Letter of Transmittal

CRS# 60465860
Burbank Ranch Housing
Chapter 246-359 WAC Temp. Worker Housing
4 FAS 12 Man Housing Units

Project location: 1121 Burbank Creek Rd
Yakima, WA 98901-8352

SITE PLAN

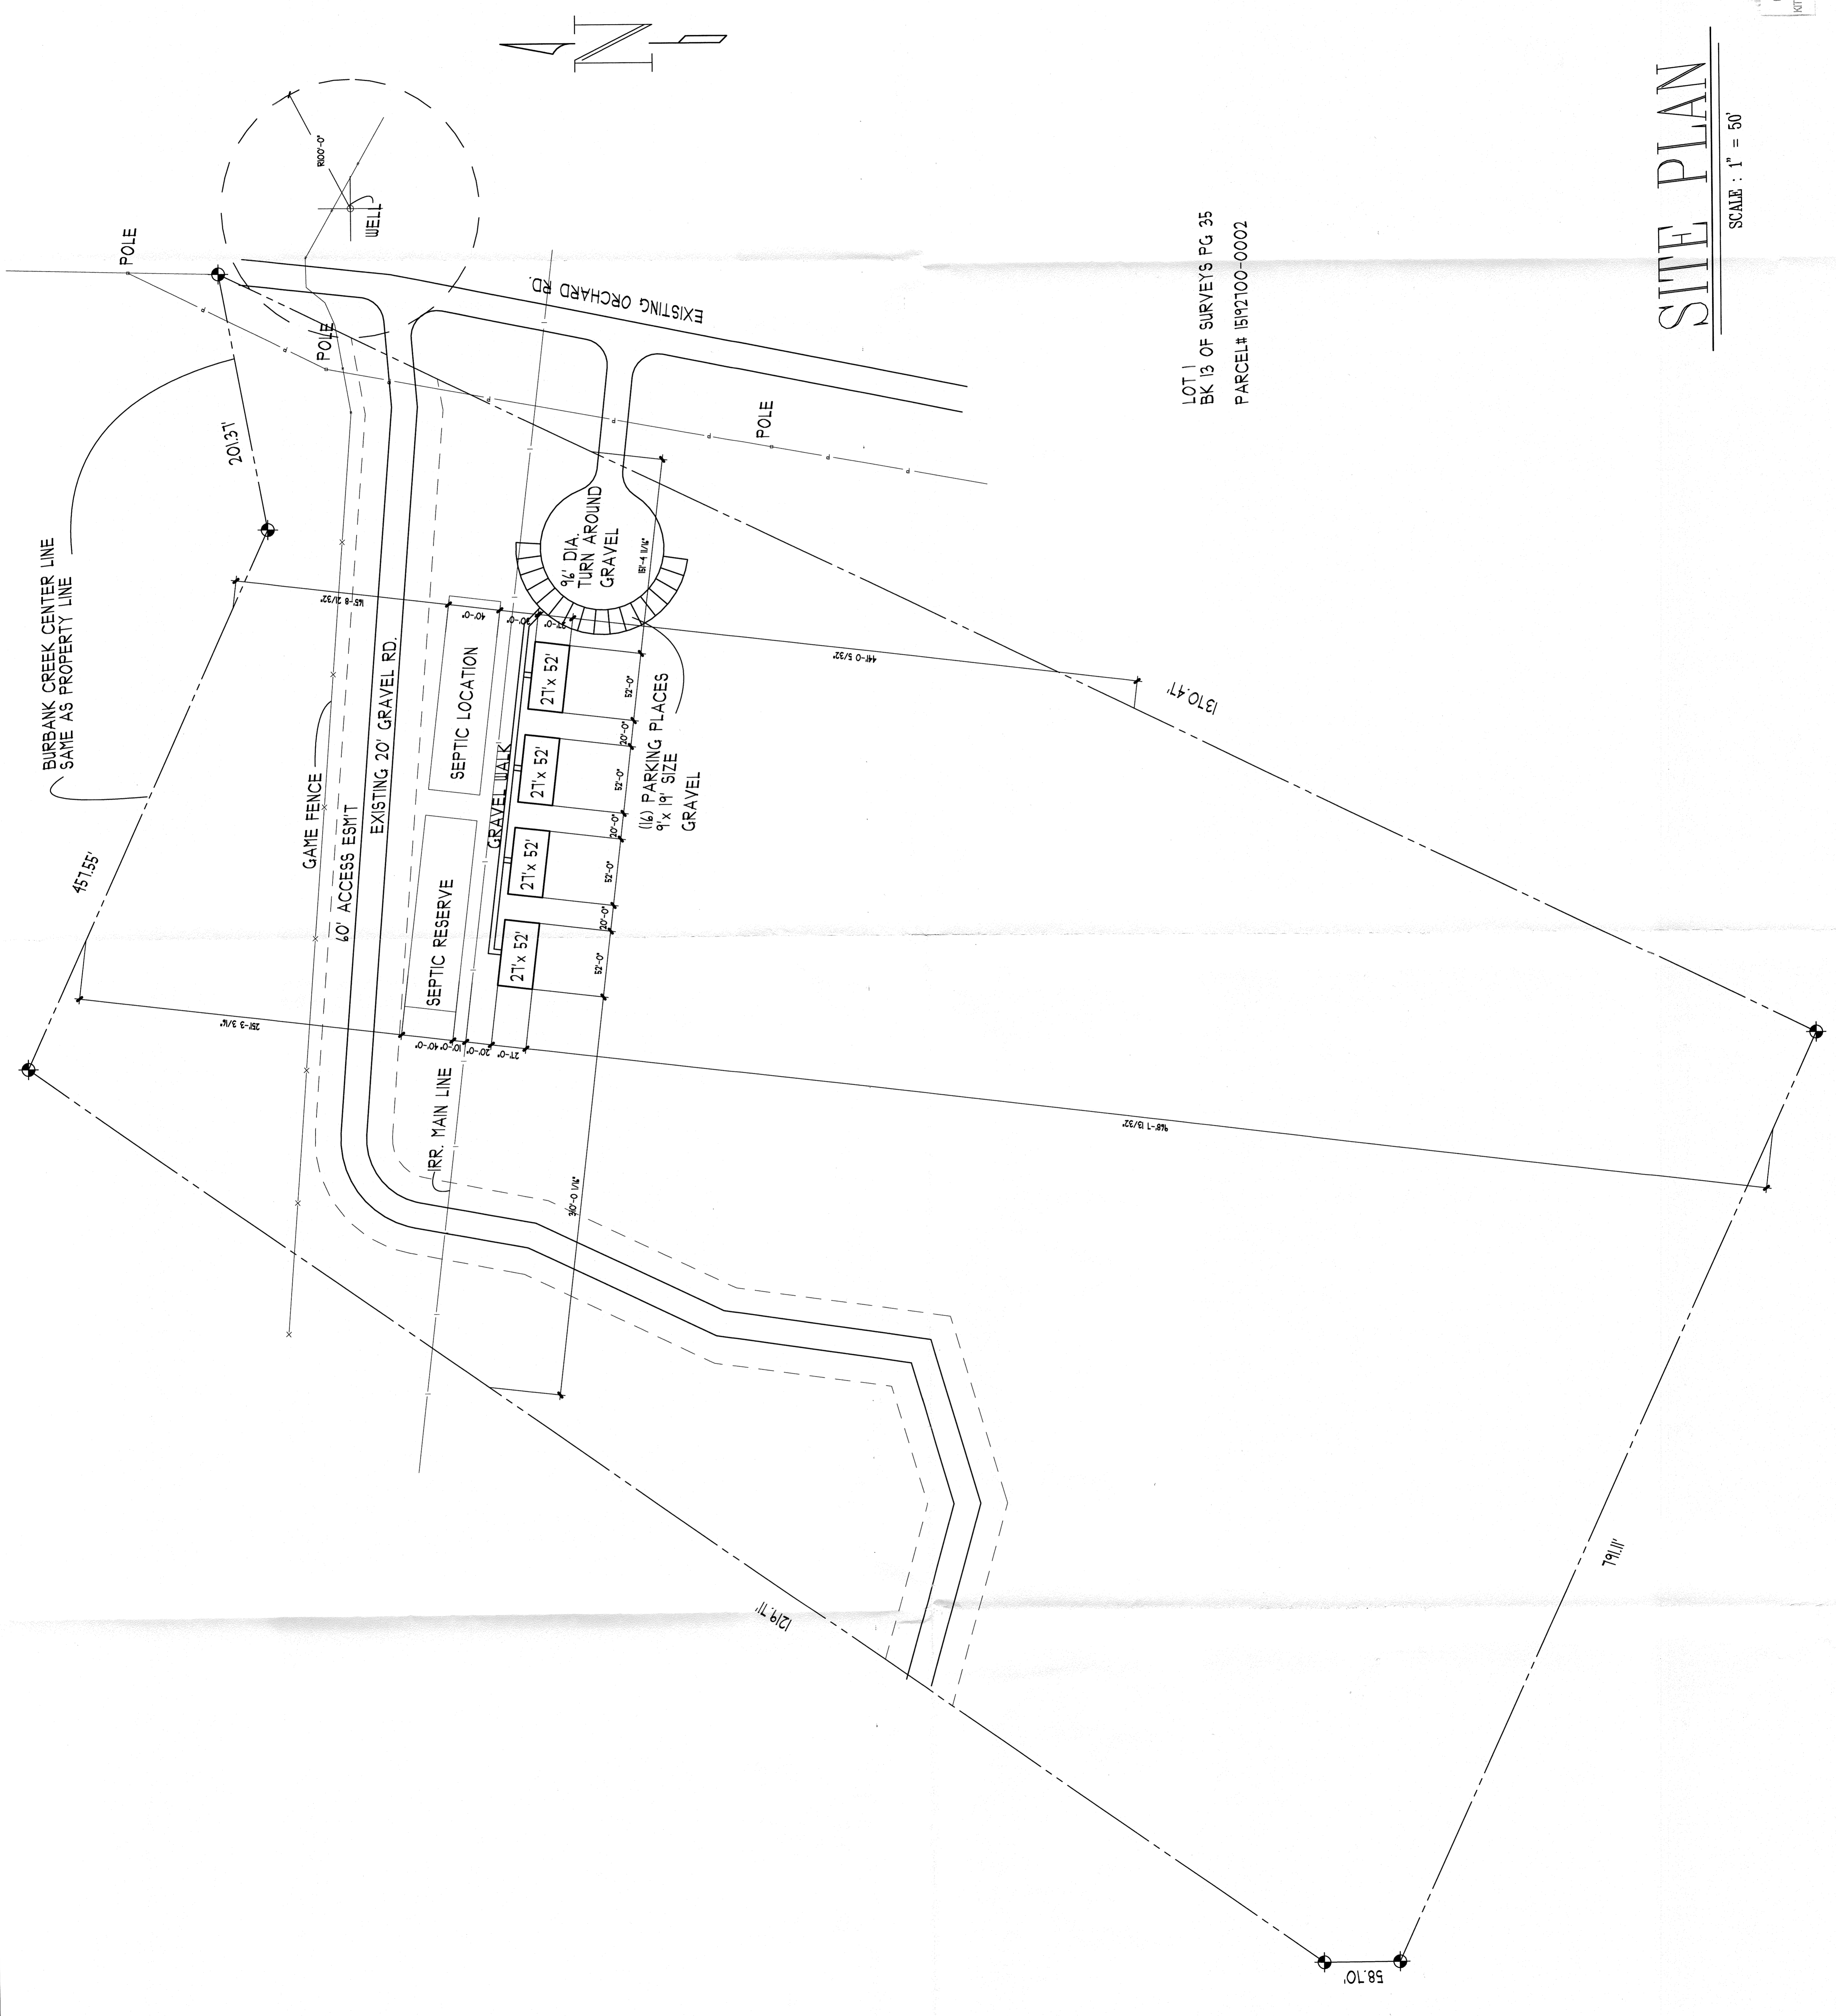
- 2 **Provide a site map and plans for this camp. Include a copy of the Assessor's map number 15-19-27000-0002, and directions to get to the site. sai**
- 3 Valley Manufactured Home, Model 5227 have been reviewed and approved as preapproved Master Plans. sai
- 4 On 5/08/2014 DOH/CRS – TWH Construction Specialist received and entered into the record 4 on-site sewage installation permits; permit #2014-11811, 2014-11812, 2014-11813, and 2014- 11808, issued on 5/07/2014 by the Kittitas County Health Department. sai
